SF18/39385
DOC18/598405

Notice of exhibition - Amending Stage 1 Concept Proposal (South Site Building Envelope) Martin Place Precinct, 39-49 Martin Place, Sydney (SSD 9347)

3 Diagram showing material of podium responding to that of 50 Martin Place

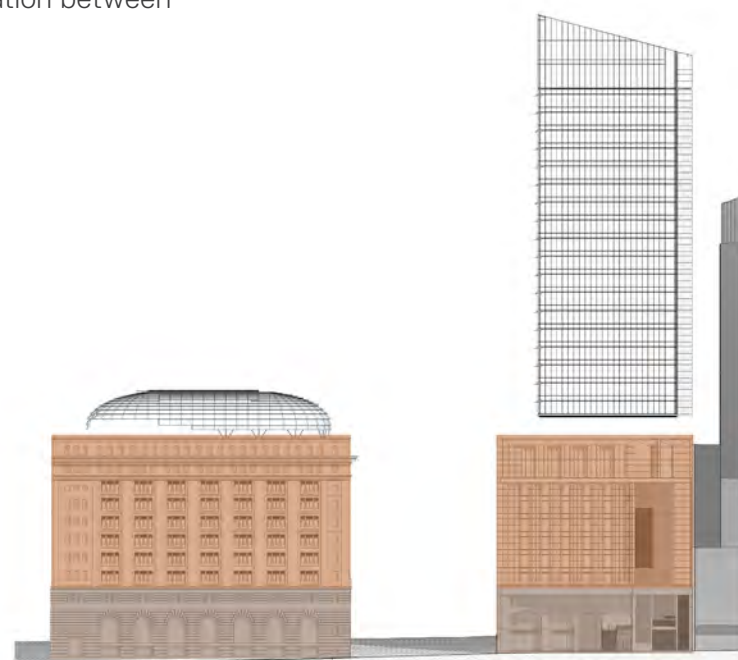
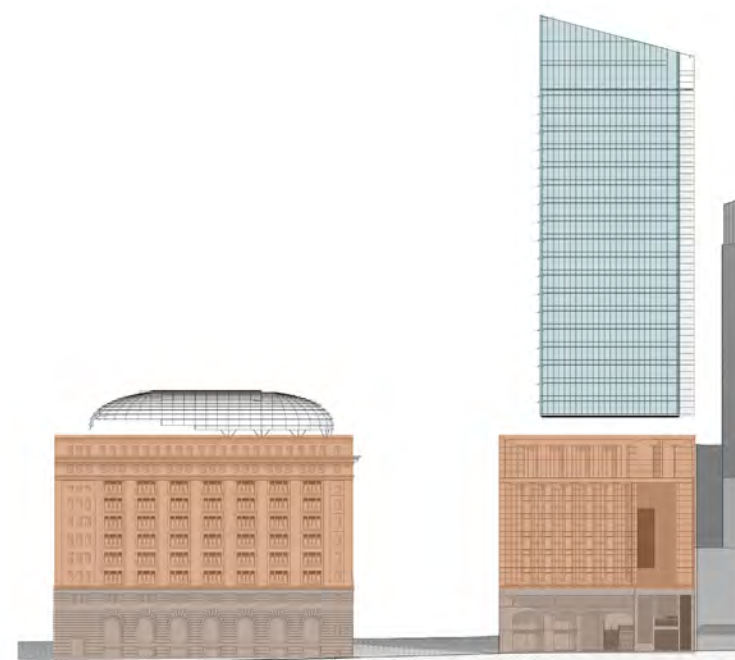
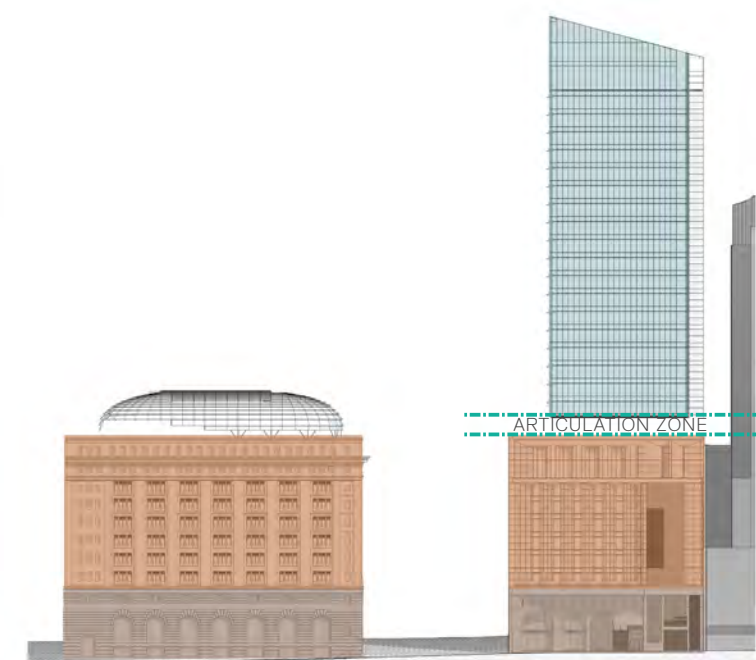
The Heritage Council considers that the future detailed design for the tower building and the podium will need to be articulated to ensure the podium is predominant and contributes to achieving the opportunity described in the HIS to reinforce the character of Martin Place, and in particular the relationship with 50 Martin Place.

Figure 5 – Relationship between the approved and proposed amended South Site building envelope

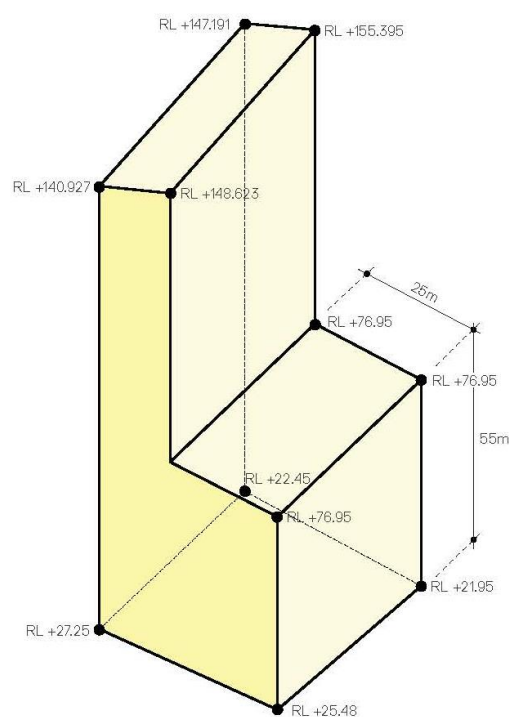
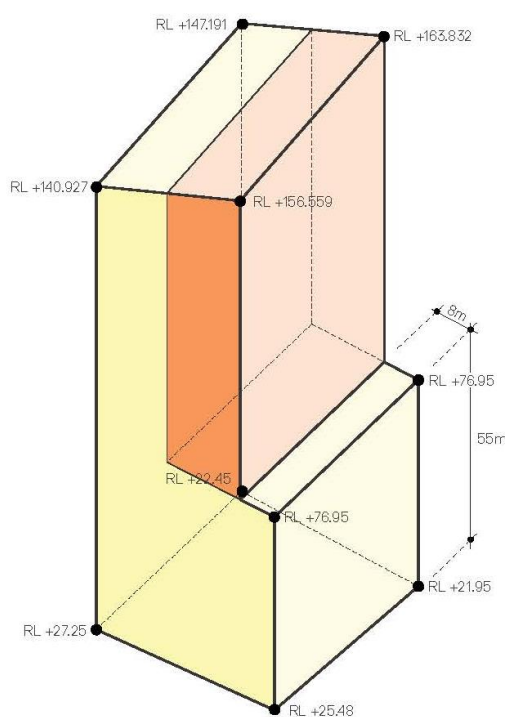
The HIS does not adequately address the greater impacts arising from the reduced setback and enlarged building envelope on surrounding heritage items and the character of Martin Place. The HIS, CDG and Environmental Impact Statement (EIS) do not assess the consistency of the amended concept design with the Heritage Development Guidelines (SOHI, Section 6) and the guidelines of the CGD, in particular *Section 2.3 Built form* (Guidelines nos. 8, 12, 13, 14 and 15).
